Subject: FW: Planning Consultation on: LU/144/22/DOC - Condition 7 - Construction Management Plan.

I refer to Construction Environmental Management Plan (Framework) DOC: LTH-RGP-SW-XX-RP-Y-XX-6809 (P05), dated May 2022. I make the following comments:-

Application No: LU/144/22/DOC
Registered: 17th May 2022
Site Address: Land South Of The Littlehampton Academy Fitzalan Road Littlehampton BN17 6ED
Description of Works: Approval of details reserved by condition imposed under ref LU/116/21/PL relating to Condition No 7 - Construction Management Plan.

APPENDIX C

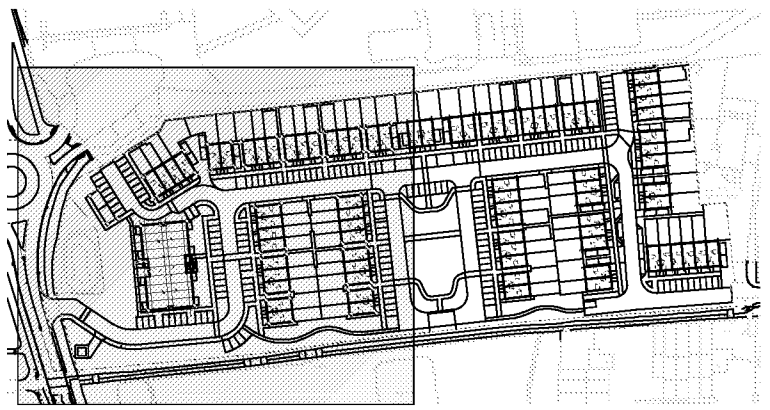
Although the text states that the haul road will be moved away from Littlehampton Day Nursery, this and the position of the site compound/welfare facilities are not detailed in any RPG drawing, or plan e.g. Annex C.

I am more flexible on the compound position which it is stated will be kept to the west and away from sensitive receptors throughout the construction works. I do however require greater clarity re the position of the haul road e.g. on a site drawing.
